**From:** Patz, Logan W.  
**To:** ["Bob@desert-sky-designs.com"](mailto:Bob@desert-sky-designs.com)  
**Subject:** F18D059 Self Storage building addition 5310 San Mateo TCL Comments  
**Date:** Thursday, November 03, 2016 1:54:00 PM

**Project Title:** SELF STORAGE BUILDING ADDITION Building Permit #: \_\_\_\_\_ City Drainage #: F180059  
 DRB#: \_\_\_\_\_ EPC#: \_\_\_\_\_ Work Order#: \_\_\_\_\_  
 Legal Description: TRACT B LANDS OF HUDSON AND HUDSON  
 City Address: 5220 AND 5310 SAN MATEO BLVD NE - ALBUQUERQUE NM 87109

C2

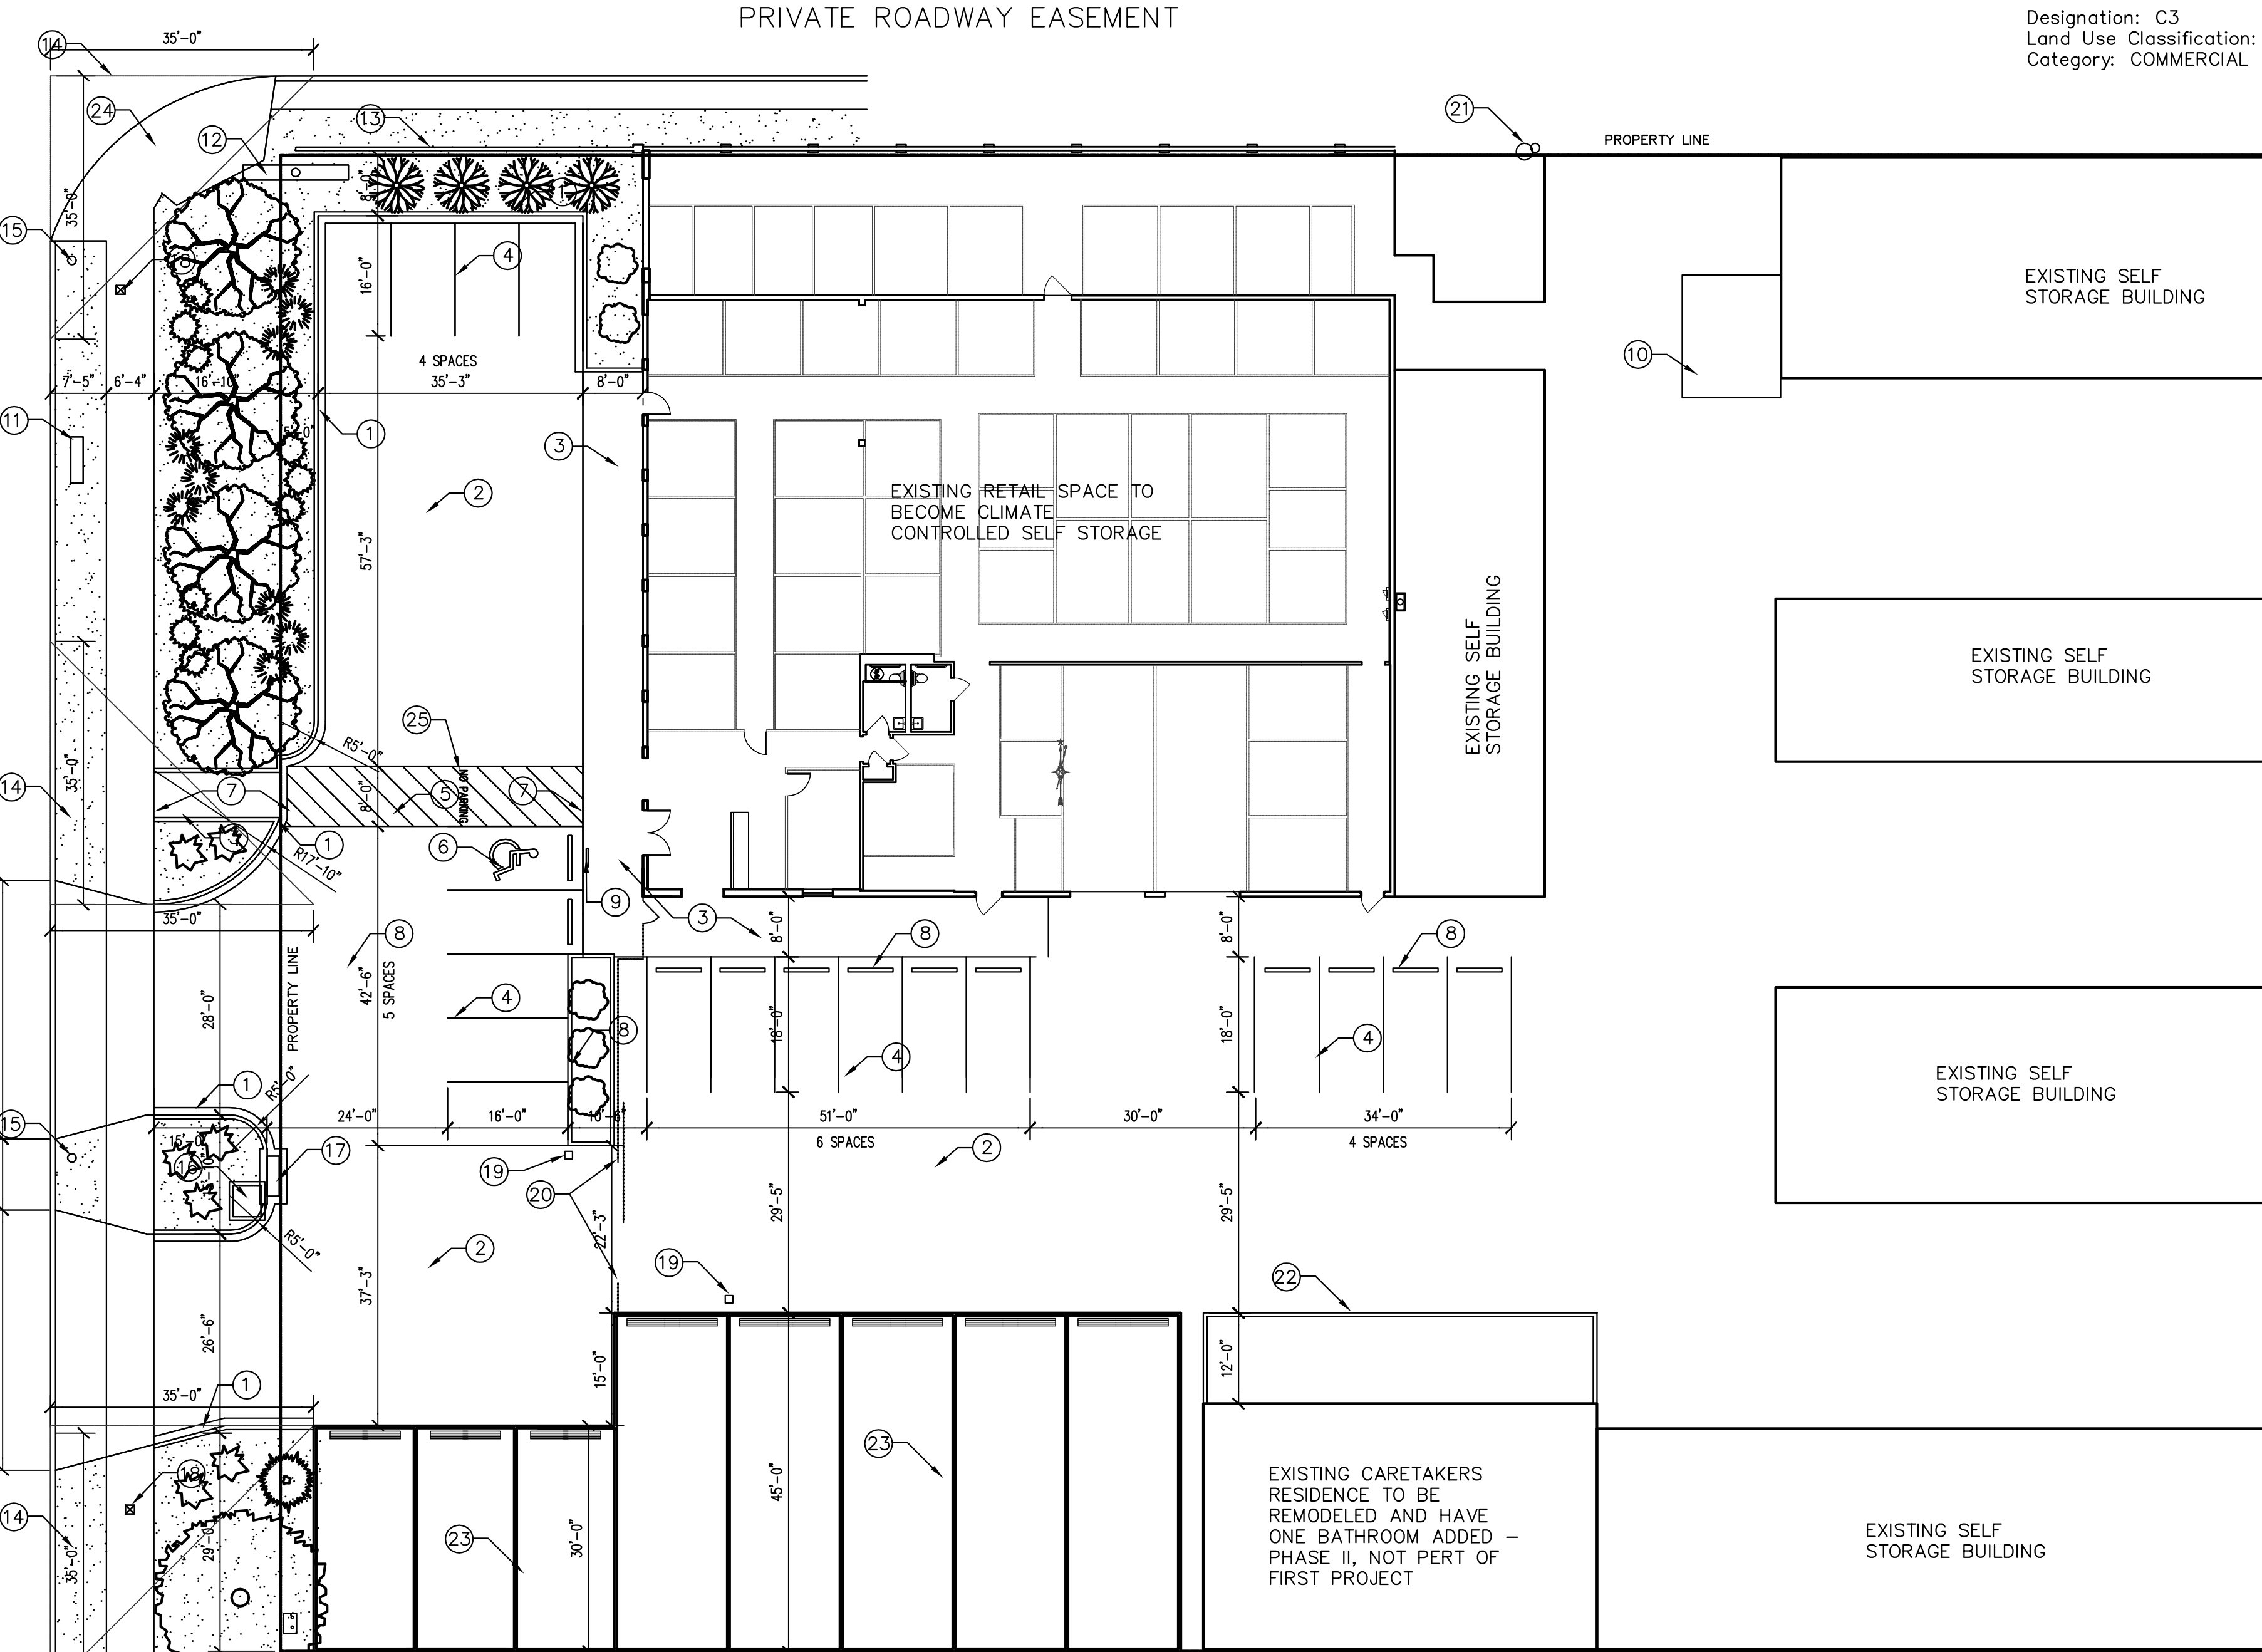
- Addressing the ADA in the notes is ok. I would like to see them in the Key Notes too.
- If you can show the words "No Parking" on the plan view in the proper location it will help the contractor.
- One of the Driveways on the San Mateo should be closed as well. You can make the remaining drive wider if you need.
